The following comments are also being forwarded to Greg Paine for inclusion in the formal response from DPI.

Key issues for Jervis Bay Marine Park in relation to the development and proposed modification continue to be as raised previously at various stages of the planning approval process. They are as follows:

TEMPORARY REVEGETATED LANDSCAPE

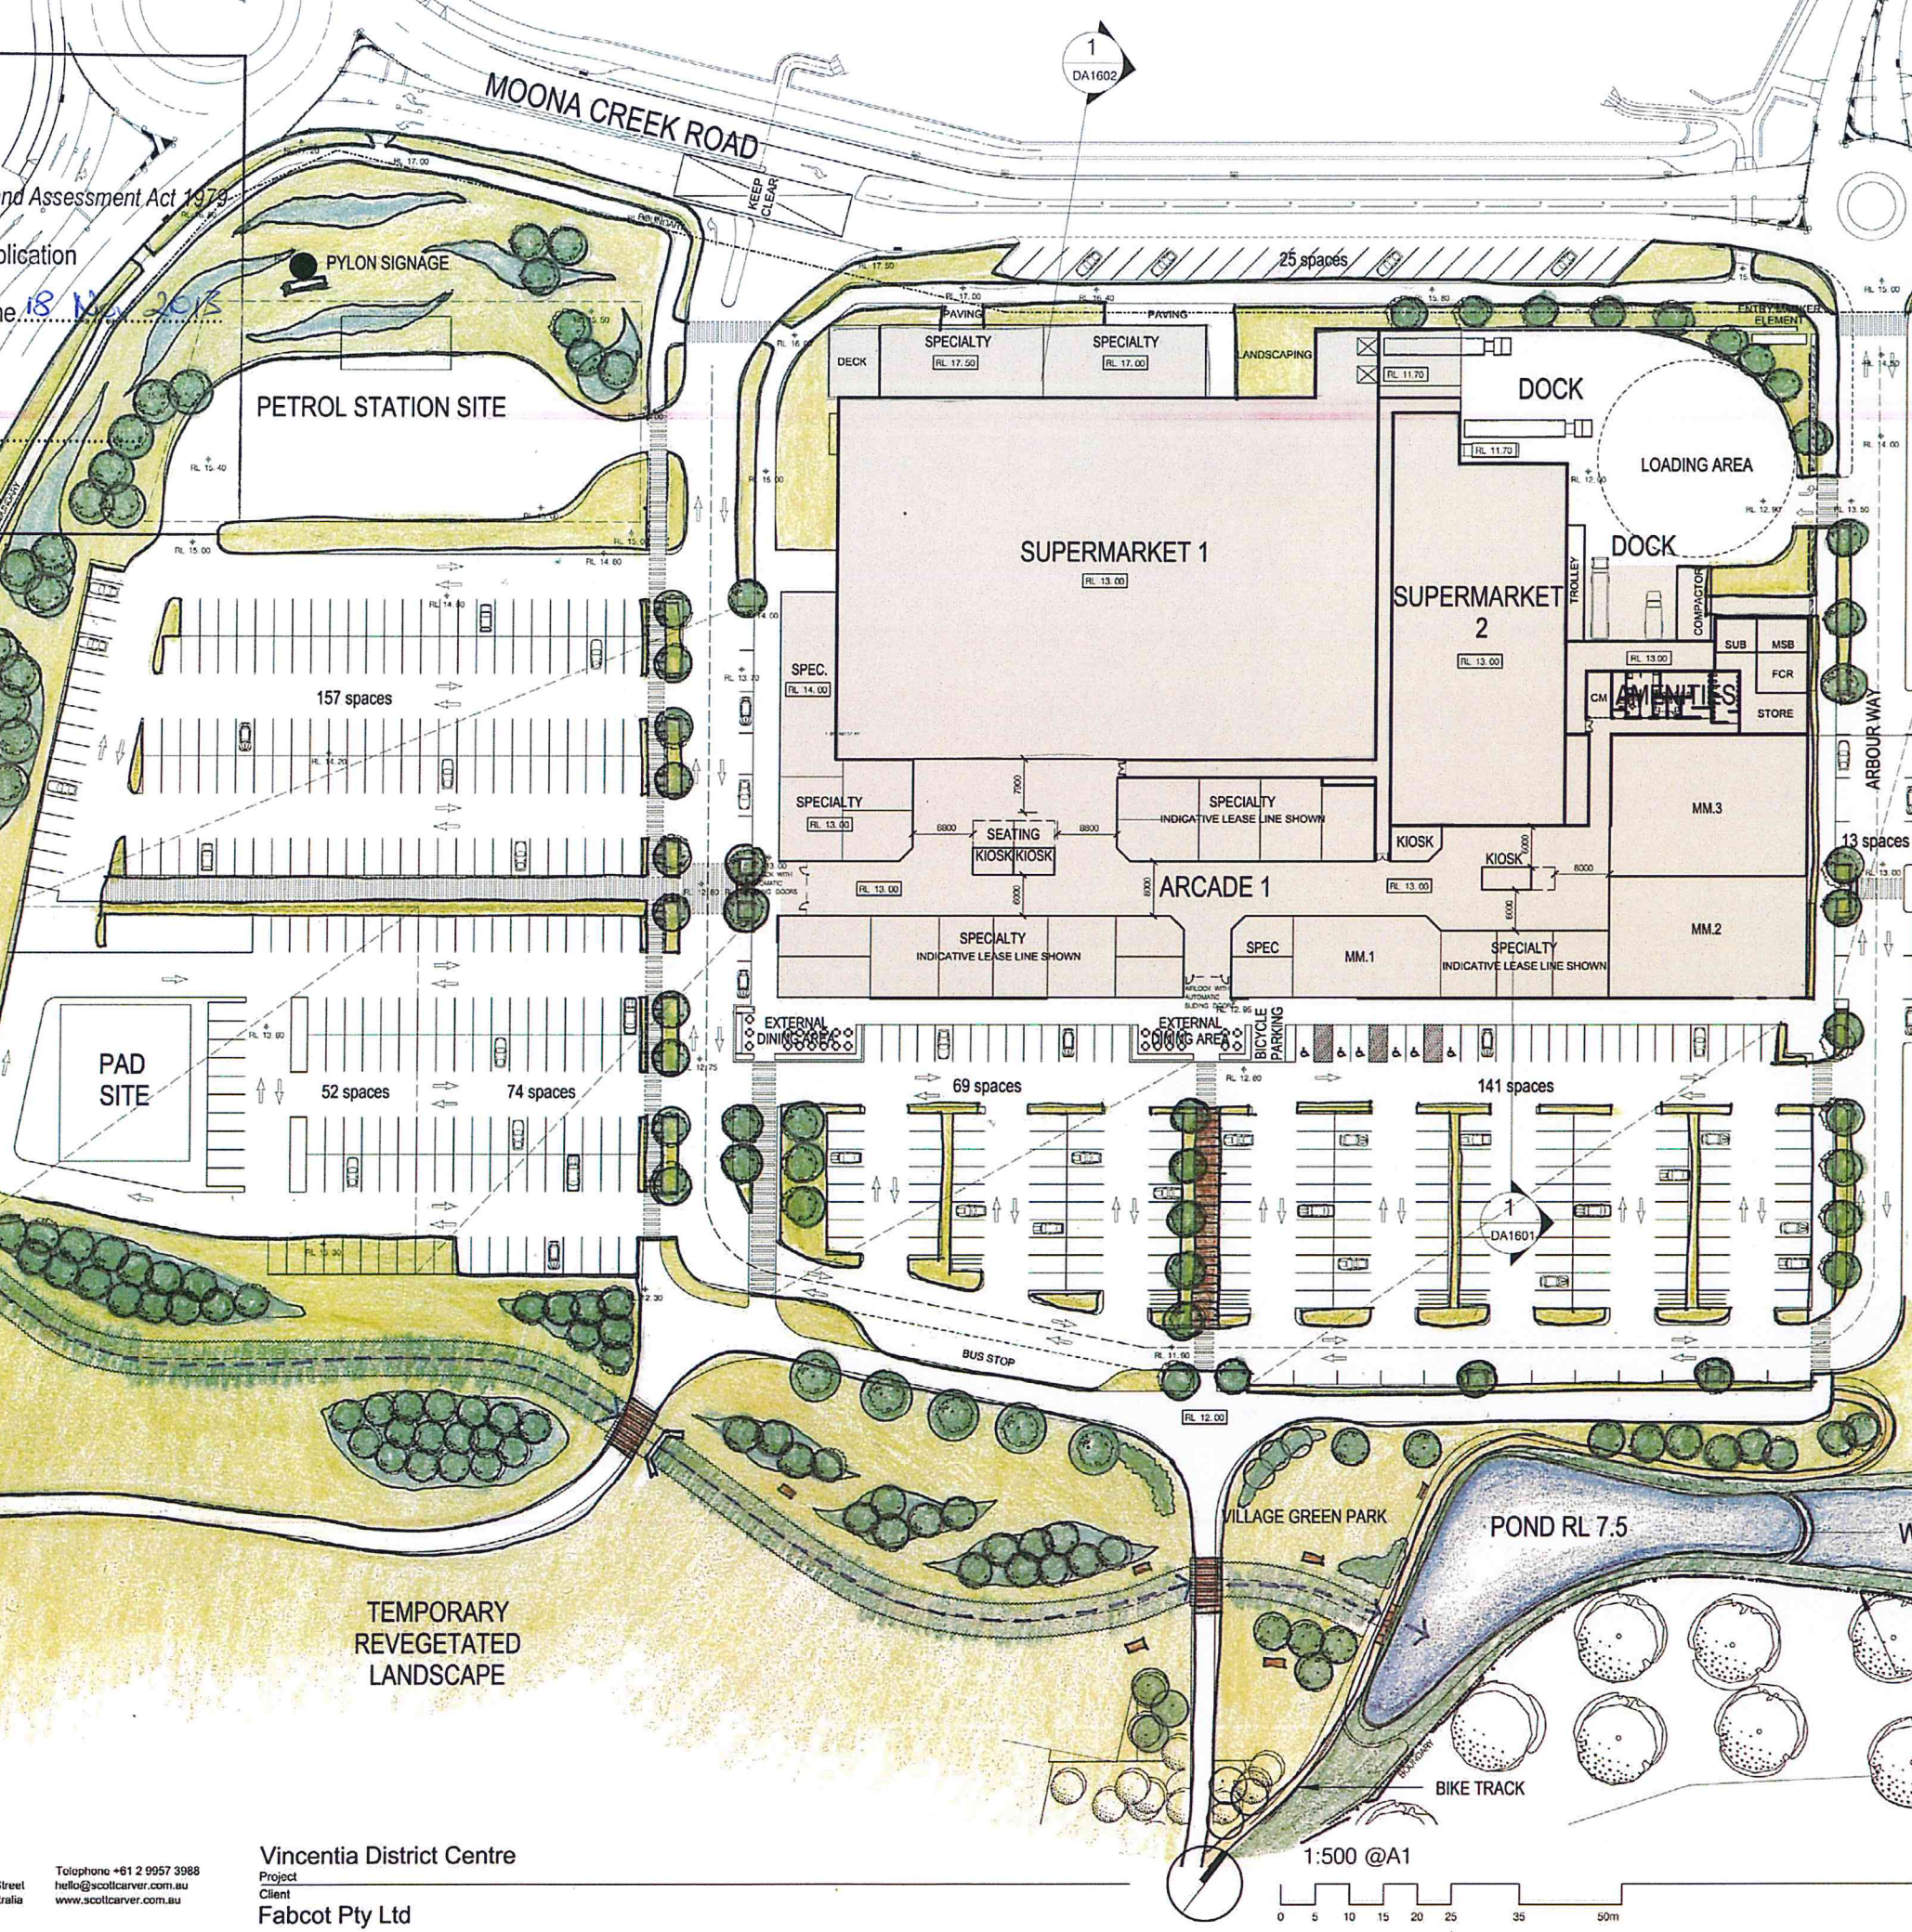
- The balance of the cleared area not now required for the modified development is identified as 'temporary vegetated landscape'. Details about how this area will be vegetated and managed need to be identified and incorporated into the Statement of Commitments. As noted above, the area could potentially be vacant for an extended period of time and any approval should include secure arrangements for effective management and maintenance of the area for the life of the development.

- In conjunction with planning for rehabilitation and management of the 'temporary vegetated landscape' the water quality sampling plan should be reviewed. Consideration should be given to increasing the frequency of sampling and/or no. of sampling sites to address the likelihood of increased levels of fines and sediments in surface water, exposed by the extensive site clearing including clearing of the creek bed itself.
